**Re: SSD-102723479 Yiribana Logistics Estate
Response to IDC Integrated Water Cycle Management Review**

Further to your request we provide this letter in relation to the above project. Specifically, we provide this letter in response to the *Integrated Water Cycle Management Review* undertaken by IDC in their letter reference *21-030 Yiribana Review v1.0 dated 9 June 2022* (refer **Enclosed**). We provide updated MUSIC modelling and **Revision D** of the *Civil Engineering Report Incorporating Water Cycle Management Strategy (inc. RtS Response)*, reference **Co13874.04c.rpt**, and the following responses (**Tables 1 and 2**) to the comments (where relevant) included in the IDC letter.

Integrated Water Cycle Management Review of the Yiribana Logistics Estate in the Mamre Road Precinct

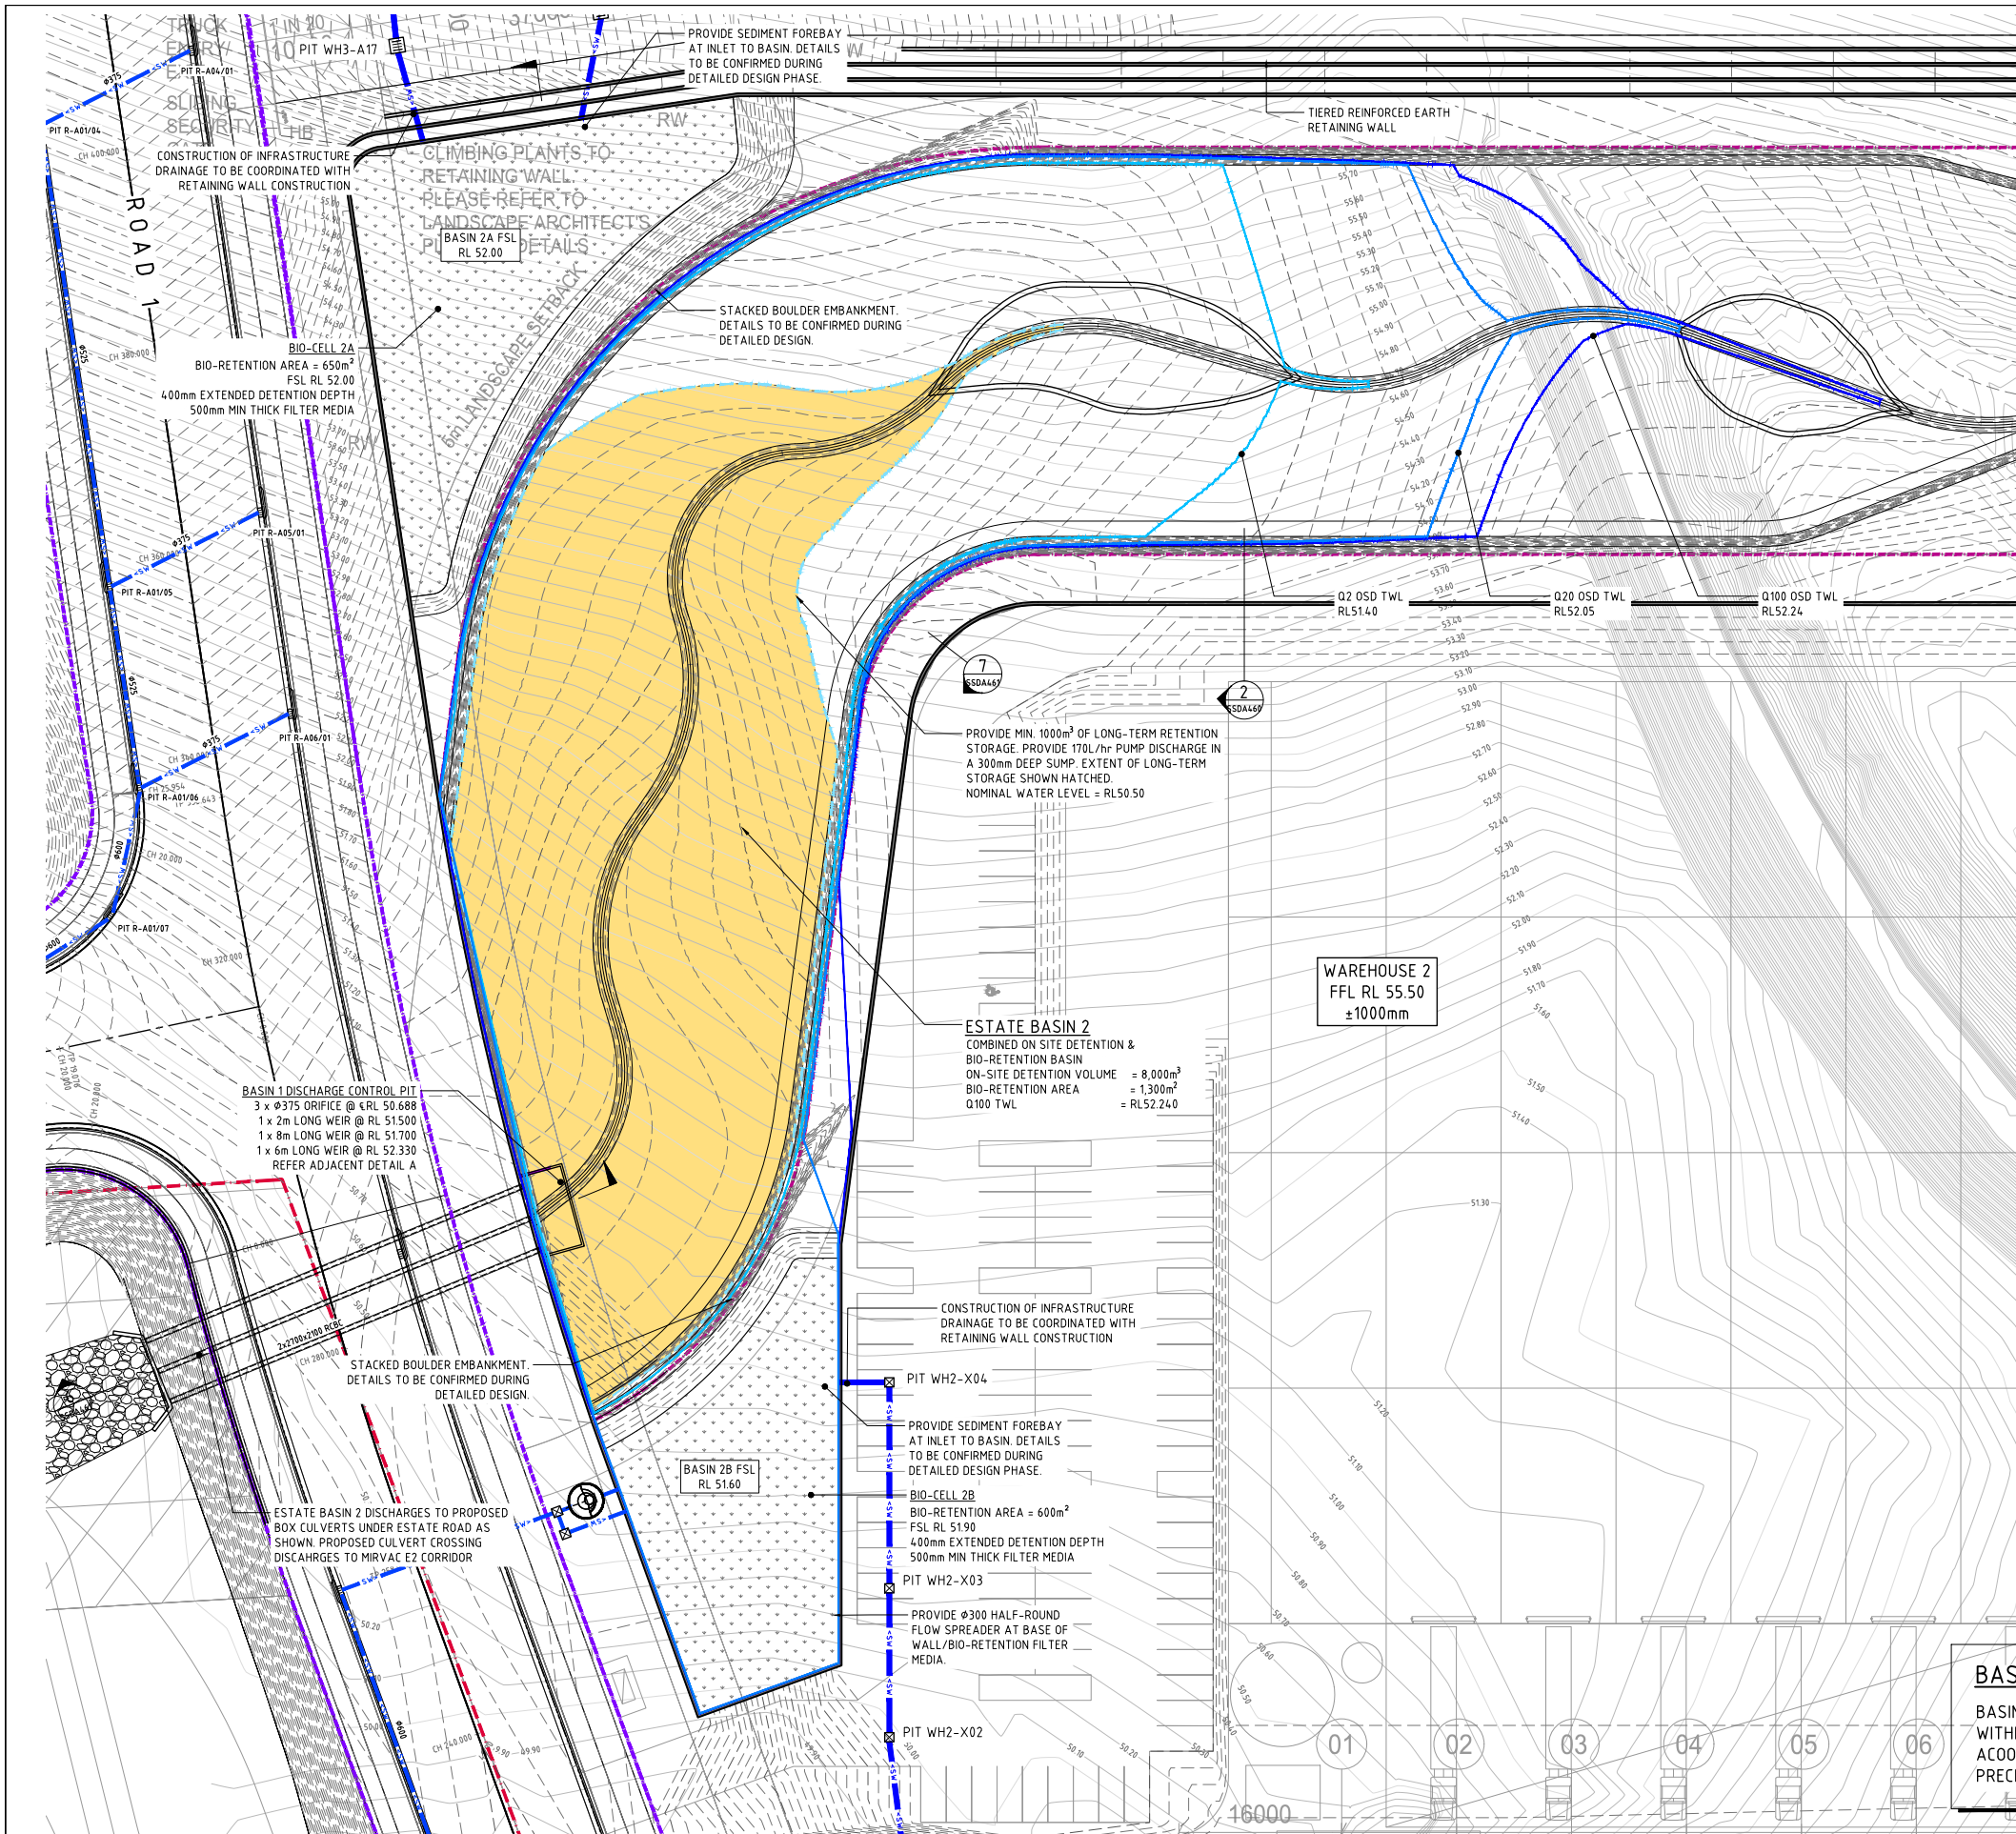
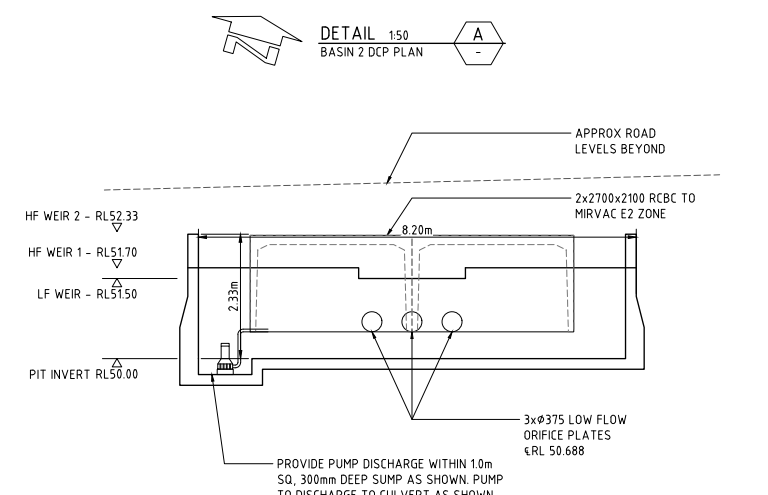
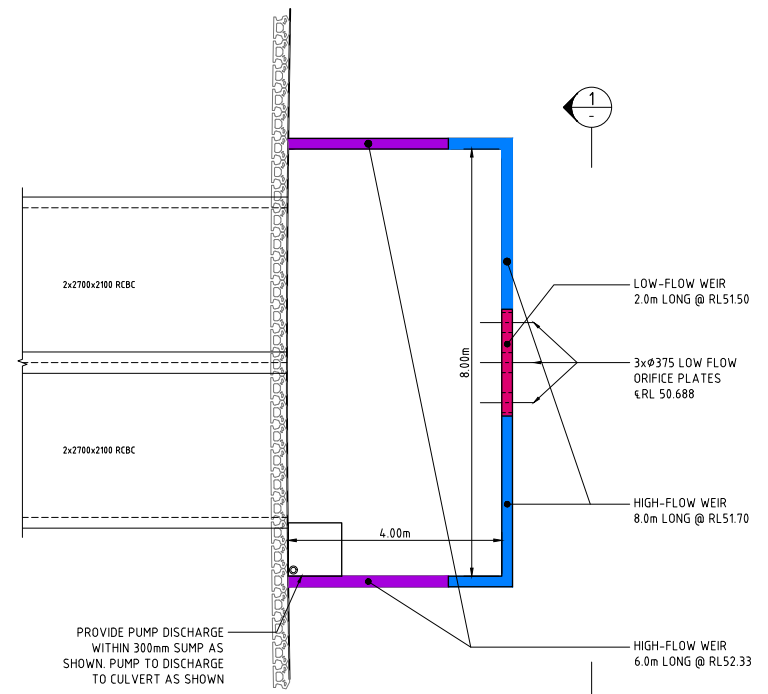
17)	High vertical walls and steep batters shall be avoided. Batters shall be vegetated with a maximum batter slope 1V:4H. Where unavoidable, retaining walls shall not exceed 2.0m in cumulative height.	No*	<i>The batter slopes comply with the requirements, but the retaining walls around the basin are considerably in excess of the maximum of 2.0m set in the DCP. However the walls are proposed to be tiered and are integral with building/pavement retaining walls (i.e. not stand alone basin walls). We believe that this is acceptable in these circumstances.</i>
